Sent: 21 October 2013 20:48  
To: Planning  
Subject: For the Attention of Miss K. Phillips - Your Ref: S6/2013/1886/FP

**Re: Erection of Two Storey Side and Rear Extension, Loft Conversion and Front Bay Windows at 5 Orchard Close, Cuffley, Potters Bar**

H.M. LAND REGISTRY		TITLE NUMBER	
		HD349125	
ORDNANCE SURVEY PLAN REFERENCE	TL 3003	SECTION B	Scale 1/1250 Enlarged from 1/2500
COUNTY HERTFORDSHIRE	DISTRICT WELWYN	HATFIELD	© Crown copyright 1983

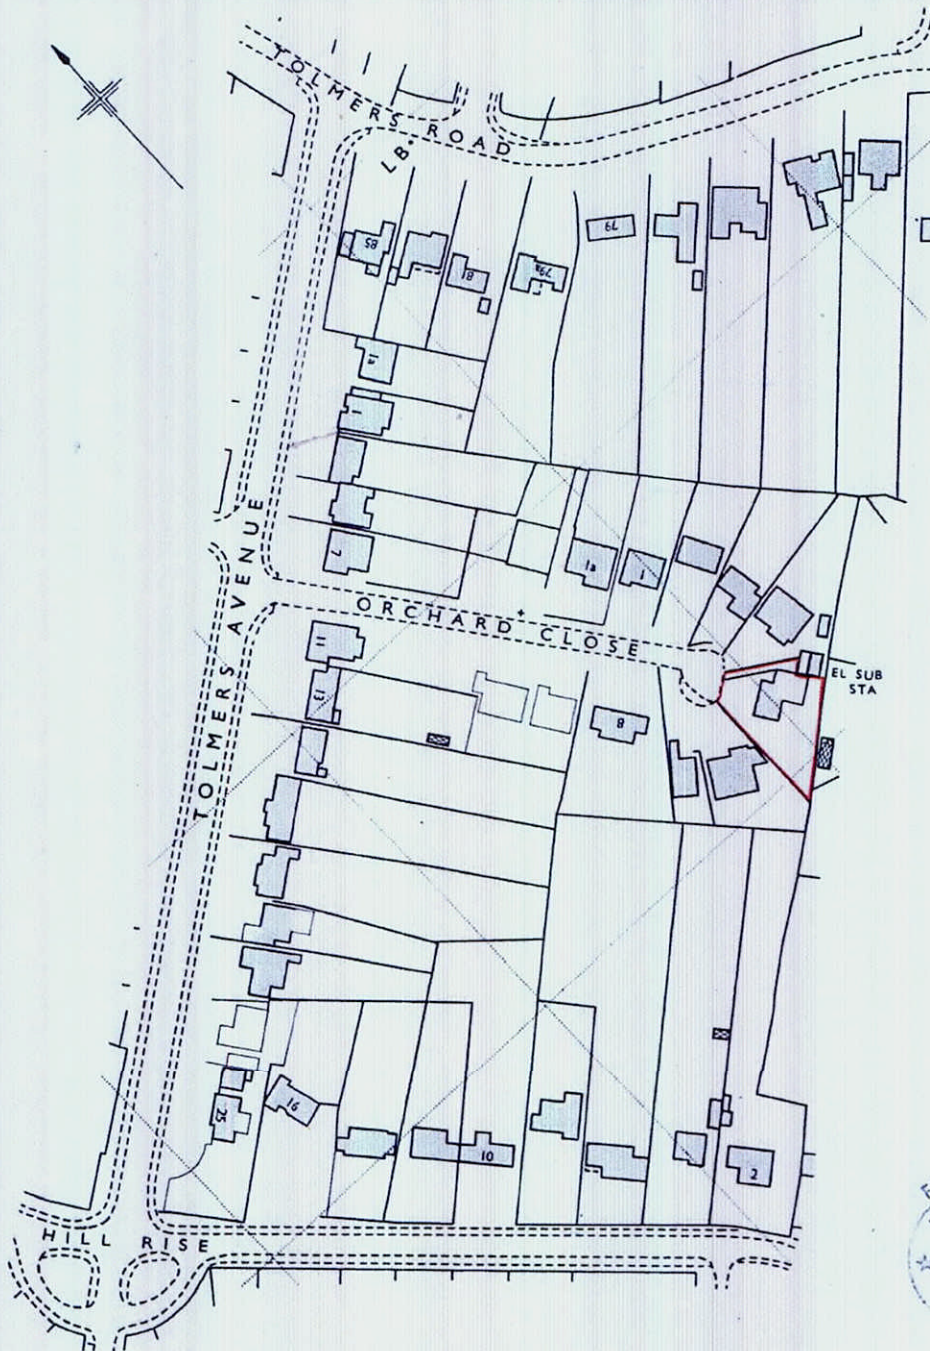
Furthermore, the "Existing Row of Trees" along the boundary of numbers 4 and 5 is also inaccurate. These trees actually run back from the road along the inner boundary line shown on the Land Registry Title No: HD349125 submitted by the applicant and they end where this Title Plan shows the original garage. They do not, as indicated on the amended site plan, form a barrier part way across the driveway to number 4 and directly in front of, what appears on the plans to be, two thirds of the sub station building. This is wholly inaccurate and totally misleading as, again, it implies that the proposed building work on that side of the property will be totally within the applicant's own boundary.

PROPOSED FRONT ELEVATION

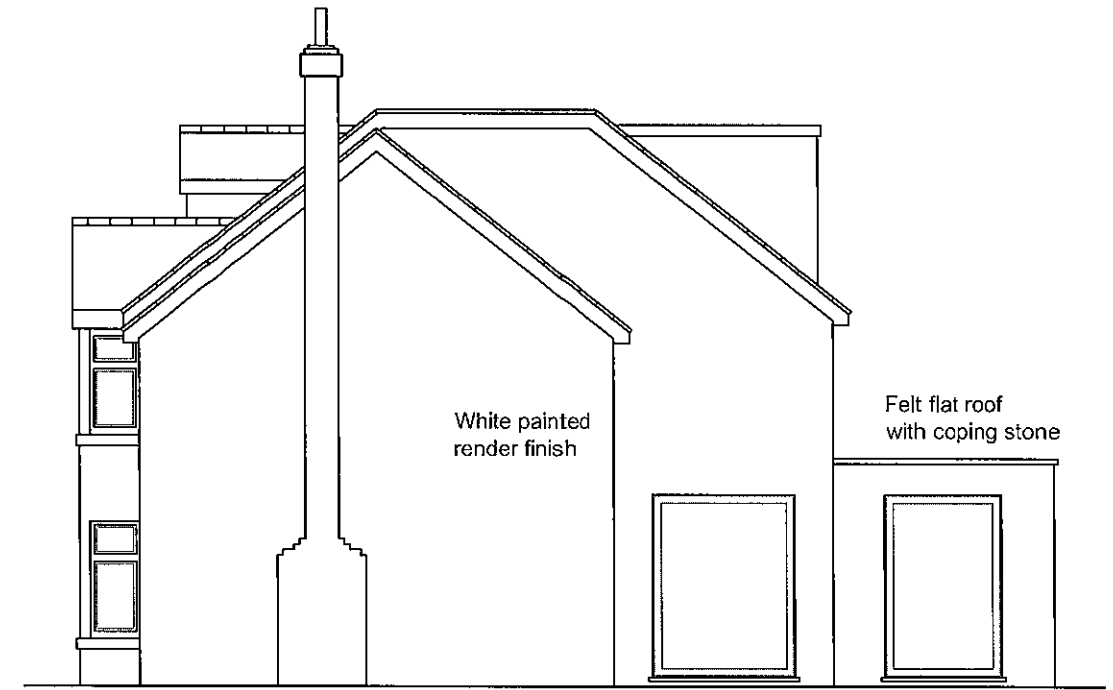
The proposed bays to the front of the property are now shown as being formed by windows. The side window of the front right upper bay will directly overlook our main living areas (those being our lounge and dining rooms) infringing upon our privacy and our personal space.

PROPOSED REAR ELEVATION

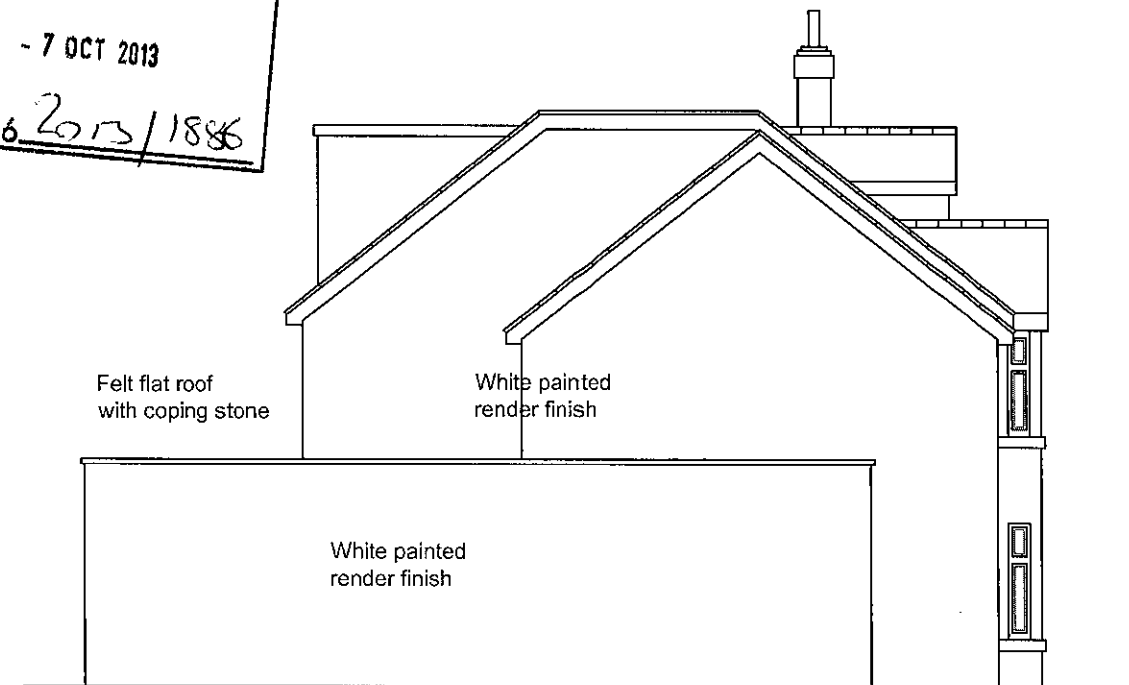
Similarly, the amended dormers to the rear of the proposed property, despite being reduced in number from three to two, are now individually larger so their potential for overlooking neighbouring back gardens remains effectively the same.

ADDRESS : 5 ORCHARD CLOSE, EN6 4QD	
PROJECT TITLE : EXTENSIONS AND LOFT	
DRAWING TITLE : SITE PLAN	
drawn MIDAS PLANNING	scale 1 / 200 @ A3
date OCT 2013	dwg no. 378/05

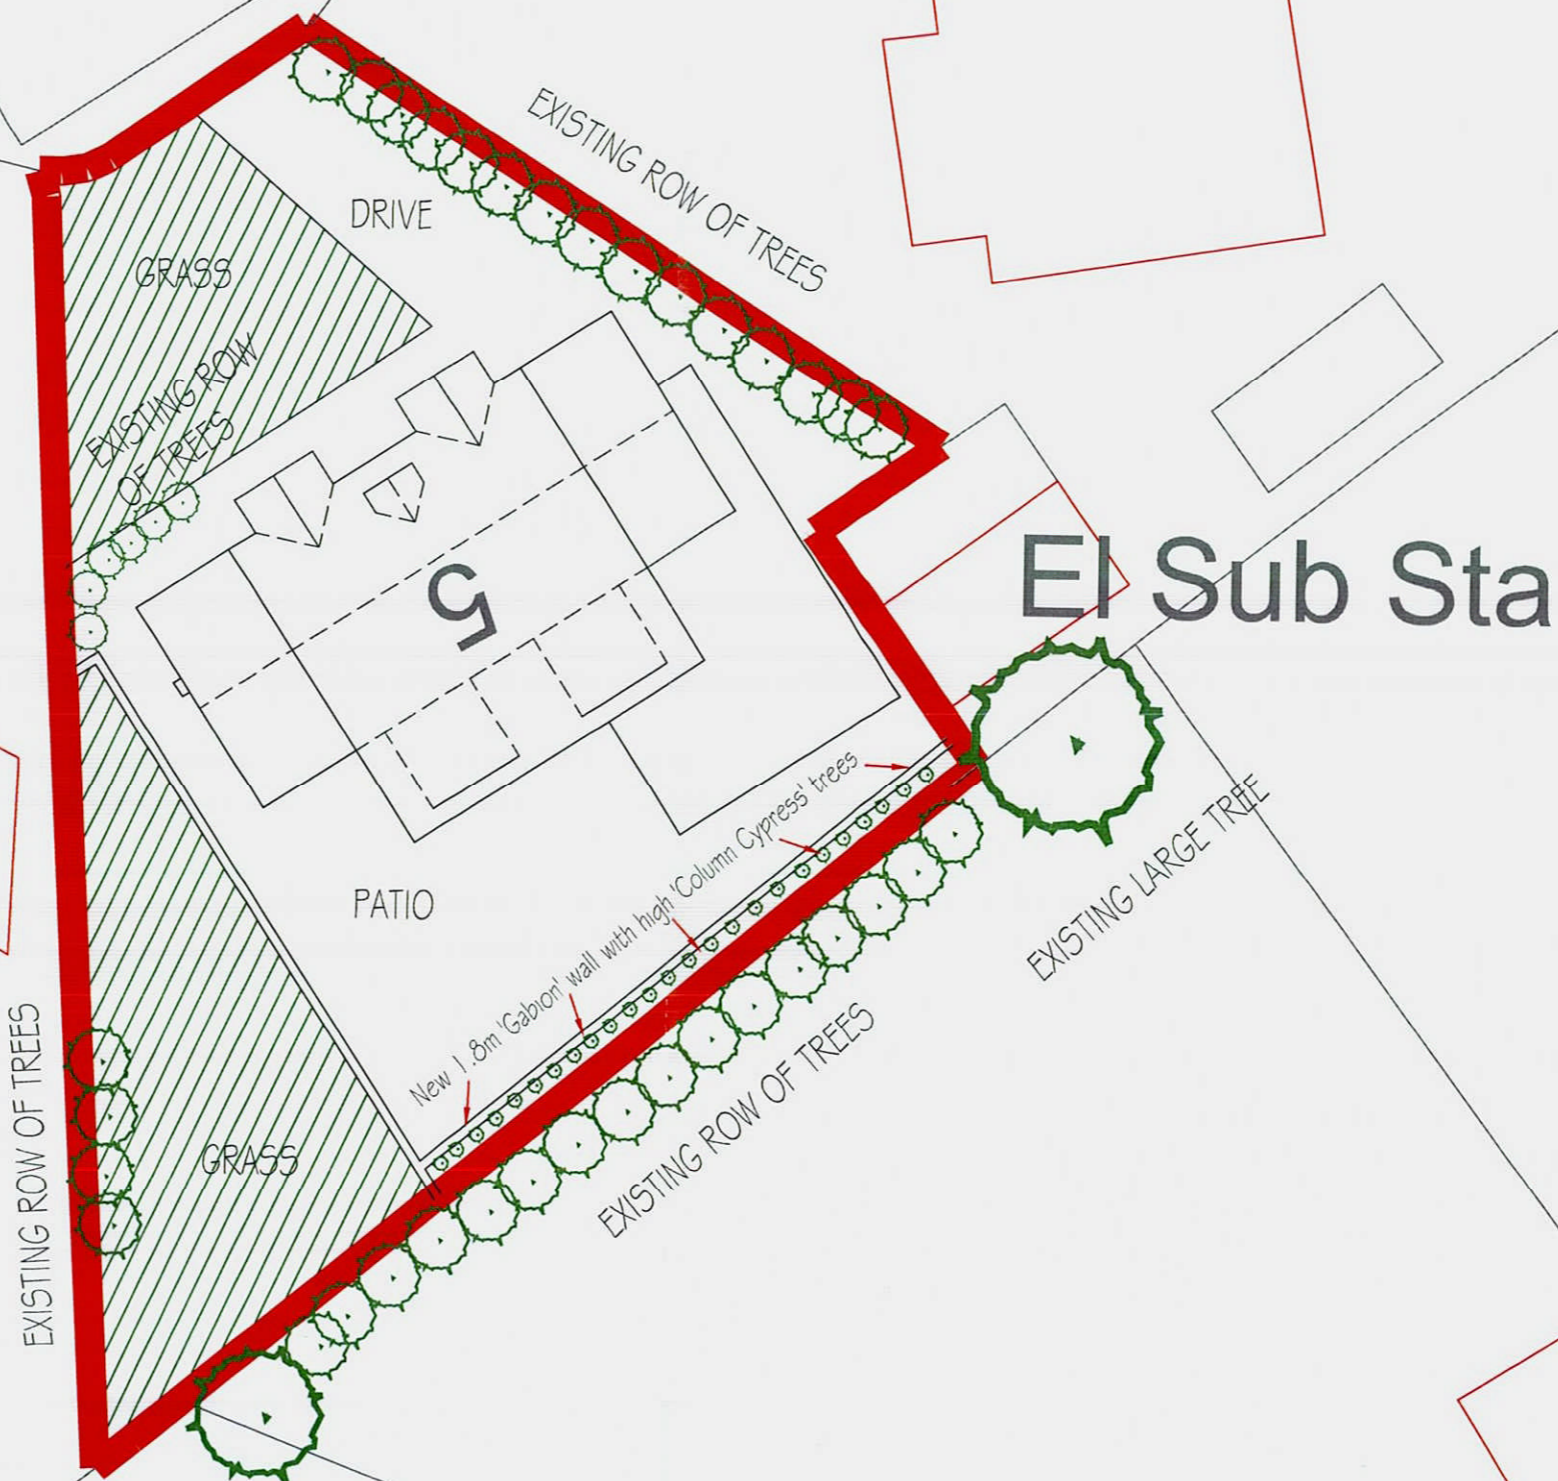
Although the new proposal indicates a reduction in the number of bedrooms from seven to five, there is still no inclusion of any garage and the frontage now shows a driveway with only limited space for off road parking. The applicant has indicated to neighbours that the revised plans will provide parking space for three cars but we fail to see how these can all be accommodated given the site plans as submitted. All existing properties in Orchard Close have garages and large driveways for their visitors' use and, as we have previously mentioned, due to the fact that number 5 is sited at the head of our culdesac, it is vital that the turning circle and other neighbouring driveways are left unobstructed.

The "Existing Row of Trees" along the border of our property and number 5 as indicated on the revised title site plan is incorrect. For the avoidance of doubt, we would like to point out that these trees were planted by ourselves well within our boundary line with number 5 and are most certainly not sited within the land belonging to number 5.
